7 July 2016

Re: | RTS Addendum - SSD 7268 Bourke Small Stock Abattoir

Project site entrance conceptual design

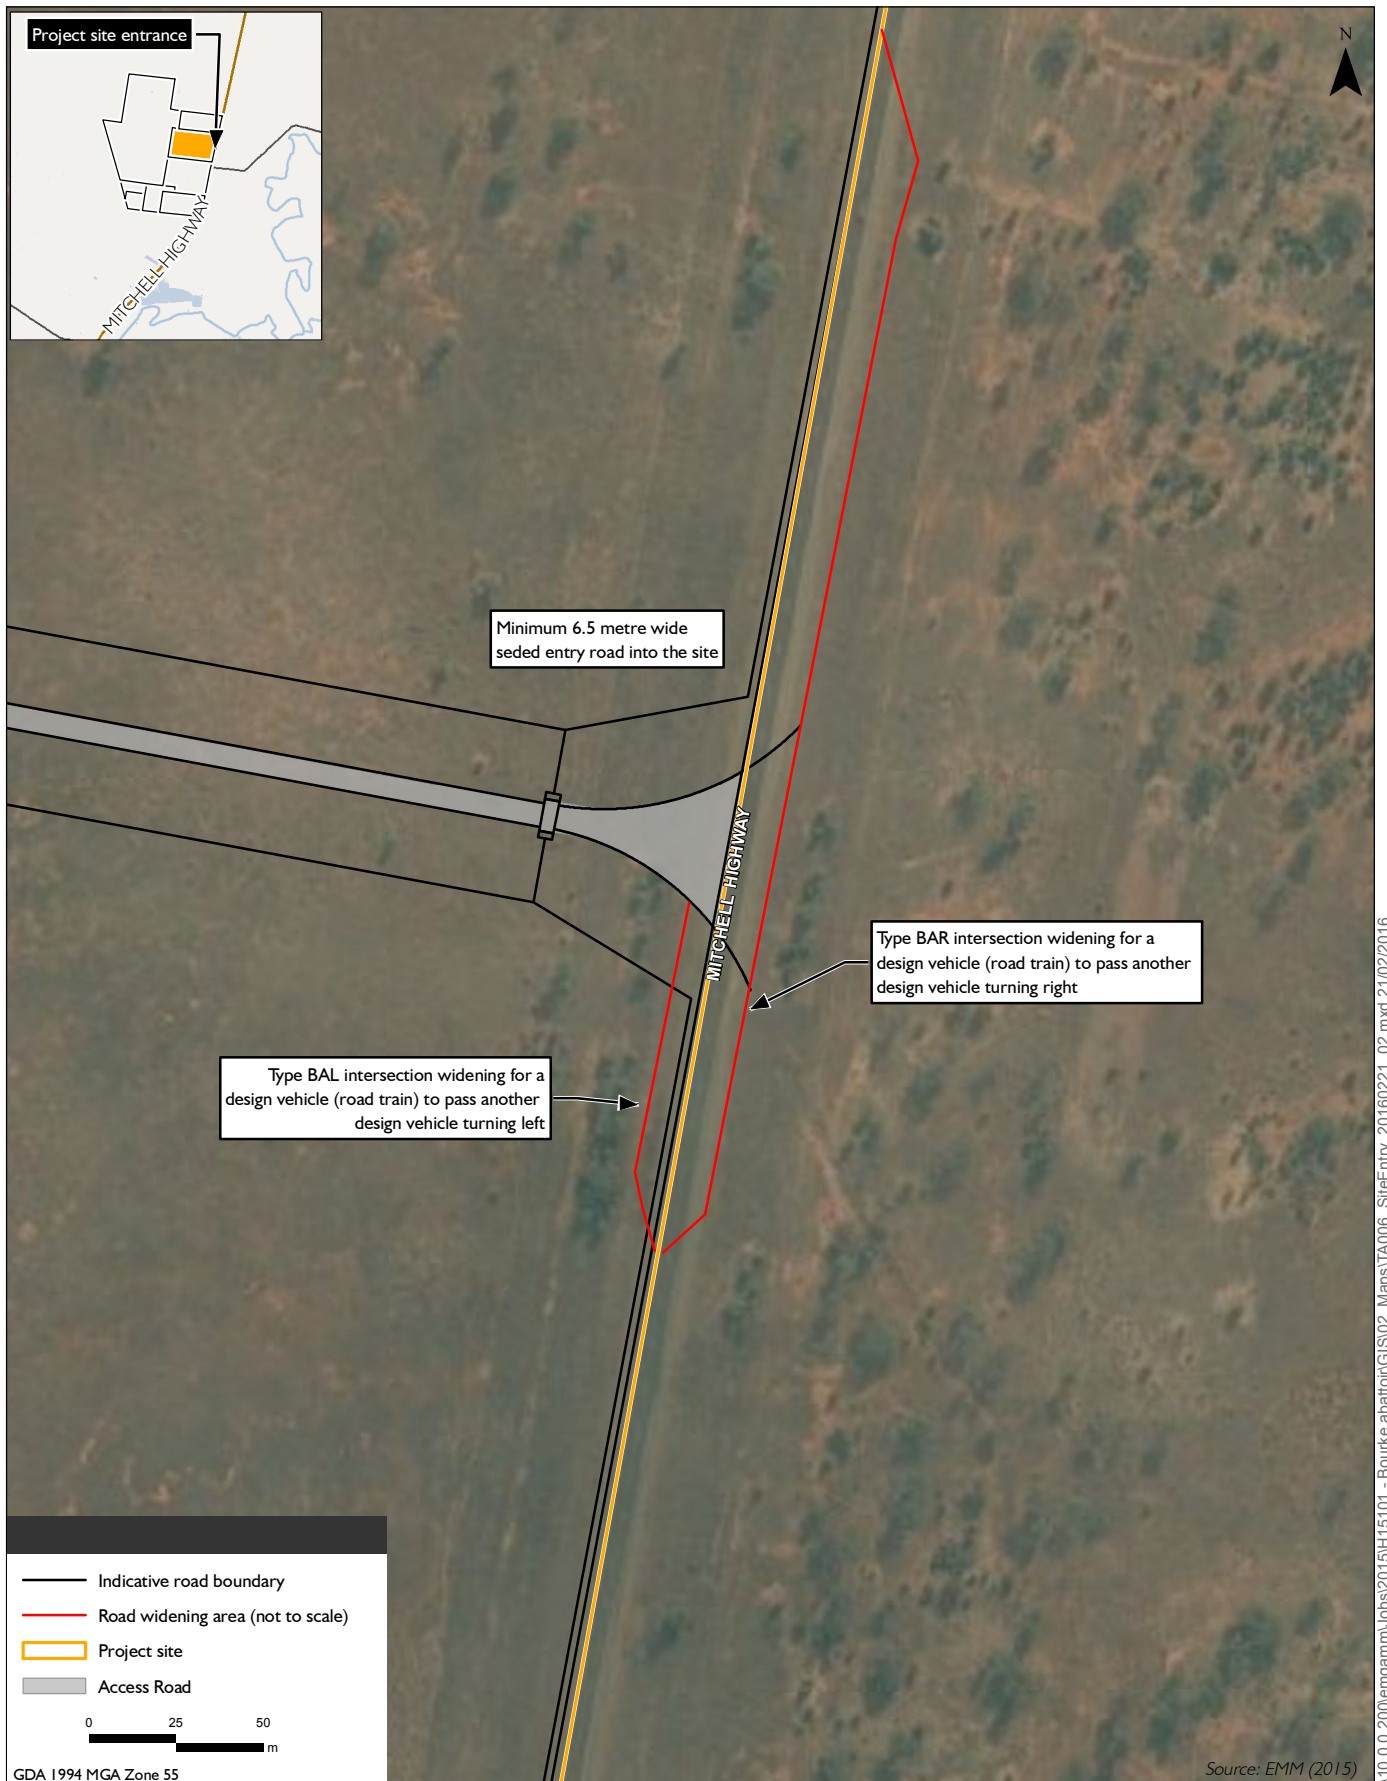
I can confirm that an AUL(s) treatment will be applied to the new intersection into the abattoir site from the Mitchell Highway, and not a BAL as originally put forward in the Environmental Impact Statement (EMM 2016) and mentioned in the Response to Submissions report. The intersection will include an AUL(s) treatment consistent with that provided in Figure 8.3 of Part 4A of *Austroads Guide to Road Design*.
